**GEARHEAD**  
CLAREMONT BUSINESS PARK  
1453 WOOLSEY HEIGHTS  
COLORADO SPRINGS, CO 80915  
EL PASO COUNTY, COLORADO

1 of 4  
SITE PLAN & DETAILS

1 SITE PLAN
 SCALE: 1"=20'-0"

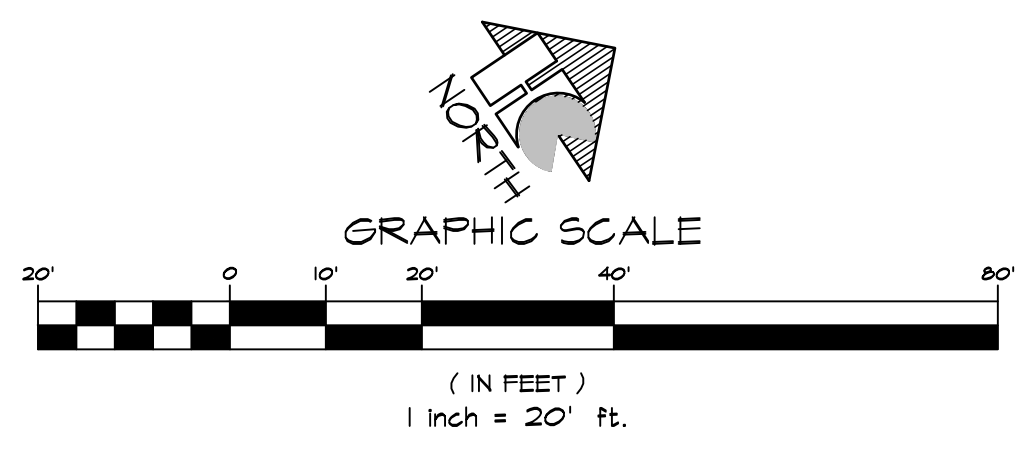
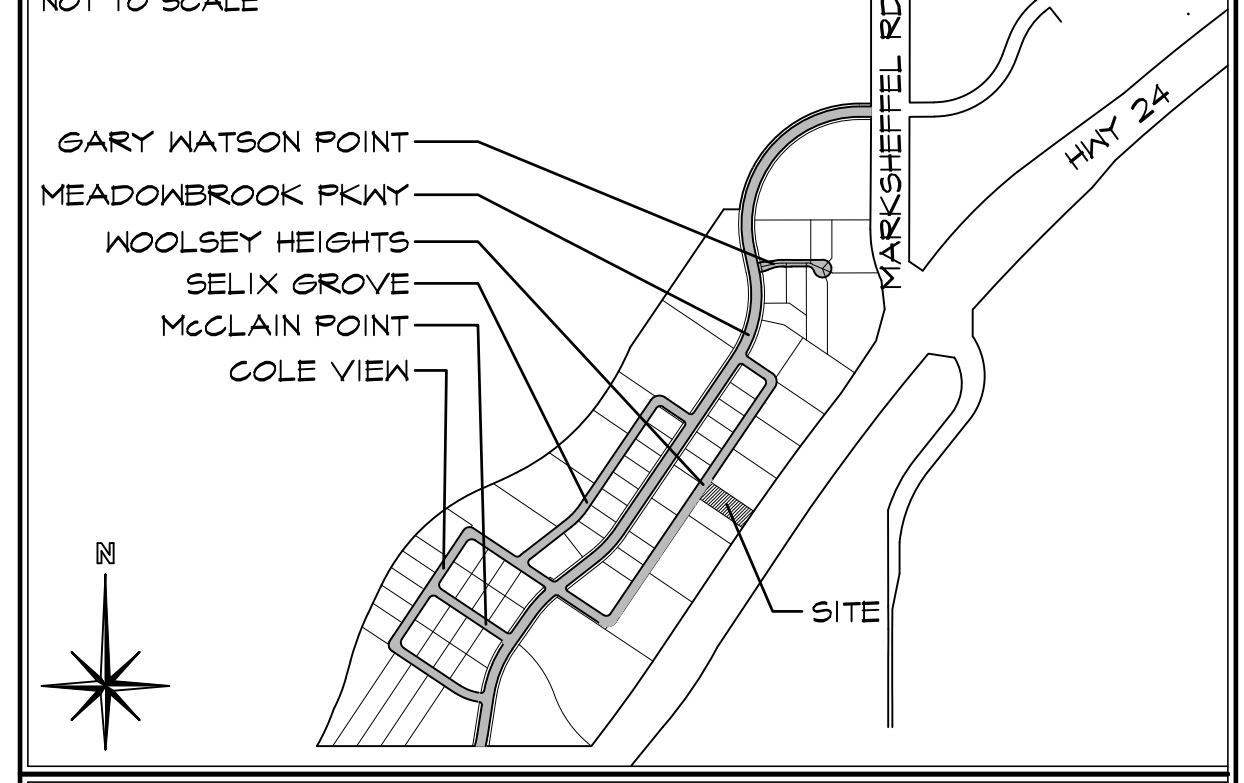
Please label access point and provide width dimension. **Added**  
Please apply for a driveway access waiver through EDARP, <https://epcdvplanreview.com/>. Under "Getting Started" click on "Initiate a minor application", select Access Permit, and enter a valid email address. The application will be sent to the email provided.  
In the application, please select "Secondary Access" the application will be sent to the access permit administrator for triage.

Please add "PCD File No. PPR-21-063". **Added**

This is the correct label according to our index for this submittal. Please update sheet number to match submittal.

This is an existing driveway which we previously applied and paid for. There is no "Secondary Access" for this site... only the previously approved driveway

1 SITE PLAN
SCALE: 1"=20'-0"

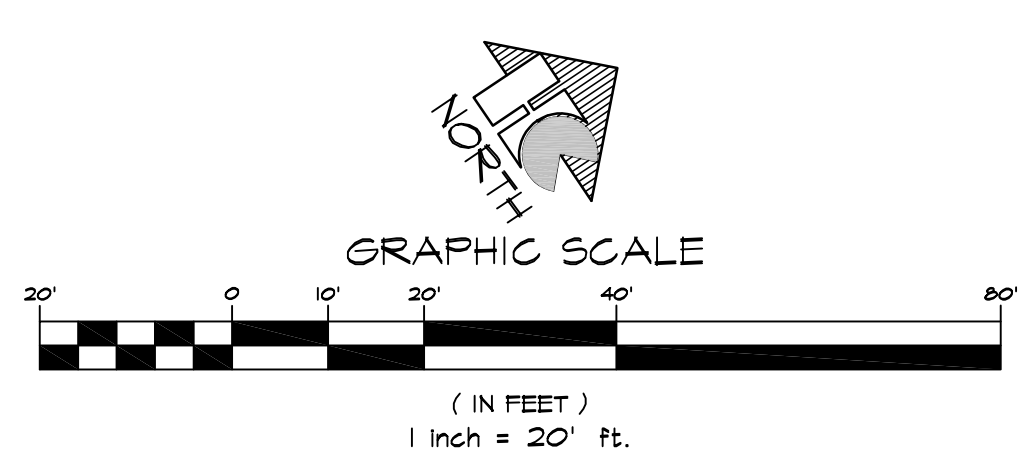
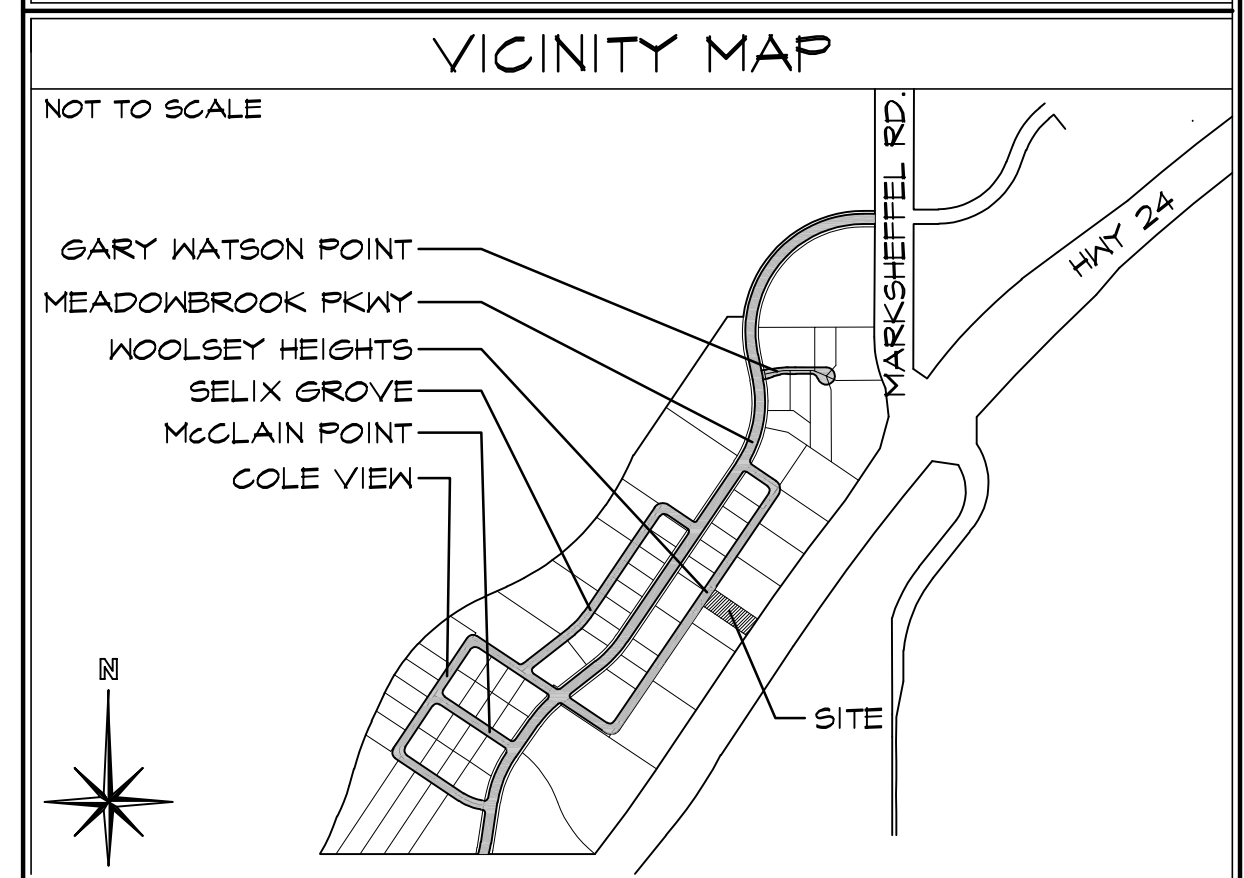
Called out existing fence to better show location on site. Existing retaining wall already called out. No sidewalk trails or berms exist on site

Existing dumpster shown on plan, screening of the dumpster was not mandatory at the time of our original submittal. We feel that since our scope of work only consists of the re-striping of the parking lot we should not be forced to comply with the new dumpster screening requirements. Adjacent property owners do not have one and they have no complaints from anyone in its existing state.
